OUT21/7465

**John Hunter Health and Innovation Precinct (SSD-9351535)  
EIS**

### Detailed advice to DPIE Planning & Assessment regarding the John Hunter Health and Innovation Precinct (SSD-9351535) EIS

Figure 8 – Bulk Earthworks Plan – refer to appendices for details

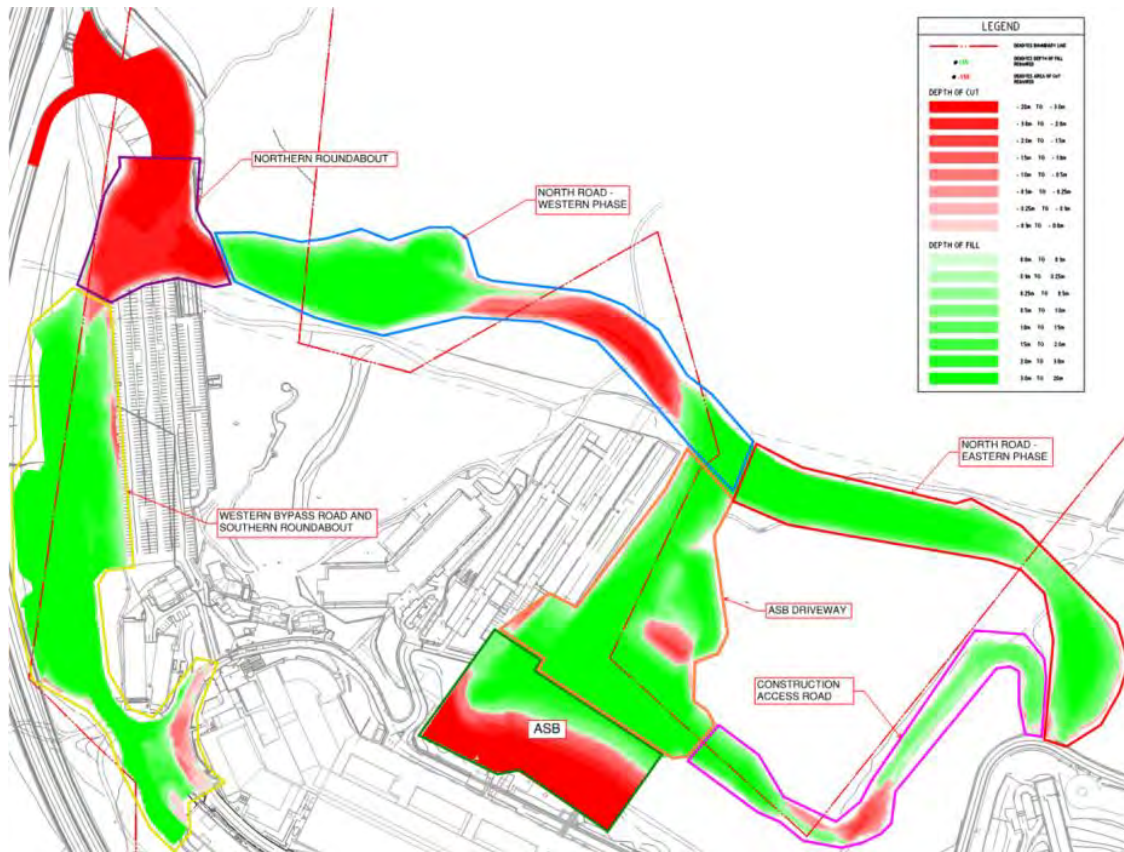
- Identify if the water table will be intercepted by cut and fill activities, and if so provide information on the predicted groundwater inflow volume generated.
- Report on whether the groundwater take is less than the 3ML licensing exemption offered under the *Water Management (General) Regulation 2018* or a licence is required.
- Provide a statement of impact against the 'minimal impact considerations' as defined in the NSW Aquifer Interference Policy (2012).

Figure 18 – Typical Site Section

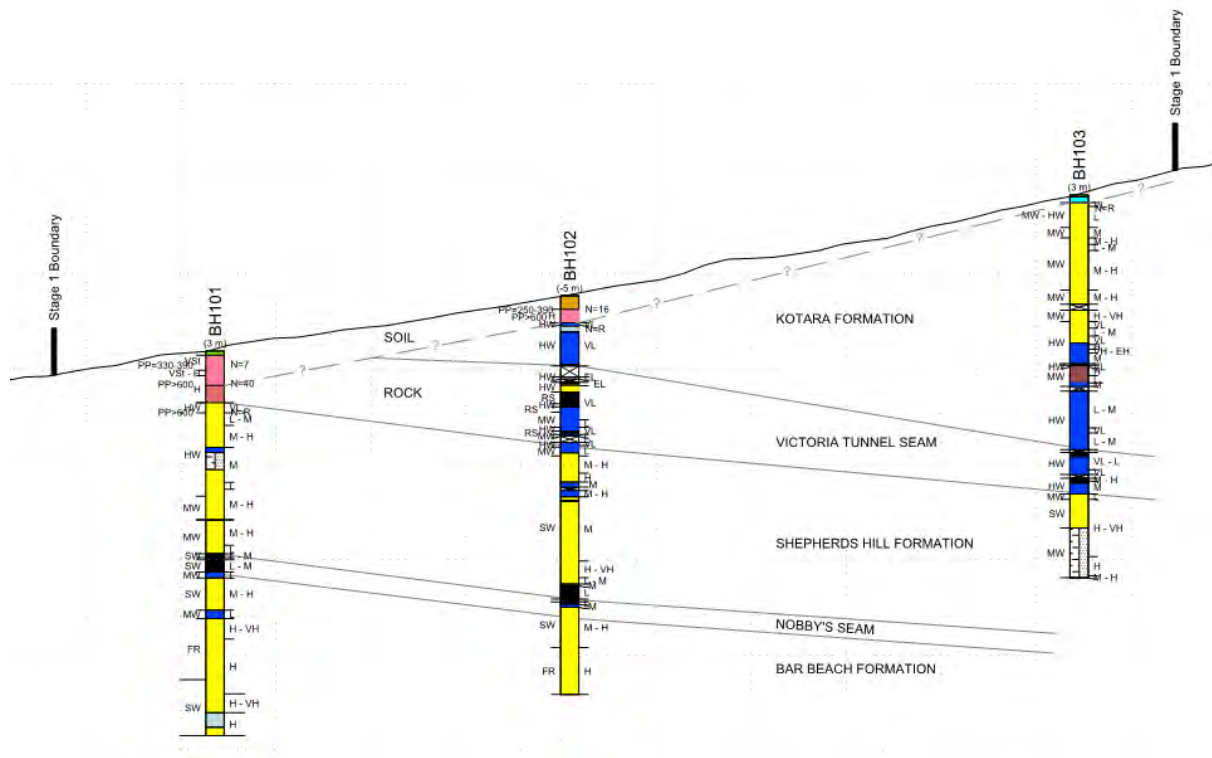
It is unclear from the EIS and supporting documentation, whether the proposed activities will result in direct or indirect take of groundwater. Grouting of historical mine workings is proposed, possibly below the depth of water table, and would potentially constitute an aquifer interference activity.

While no groundwater was intercepted during excavation of test pits that were dug to a maximum depth of 0.9 metres below ground level (mbgl), construction excavations are proposed to depths of 8-10 mbgl. The Geotechnical Assessment report indicates that two boreholes were constructed, however, no detail on water level measurements were included. Water levels of between 11.6-15.90 mbgl are mentioned in the Contamination Assessment report. The geotechnical assessment further notes that "*a detailed understanding of the groundwater conditions at the site is very important*" in relation to detailed design and construction, suggesting that interception of water table is possible.
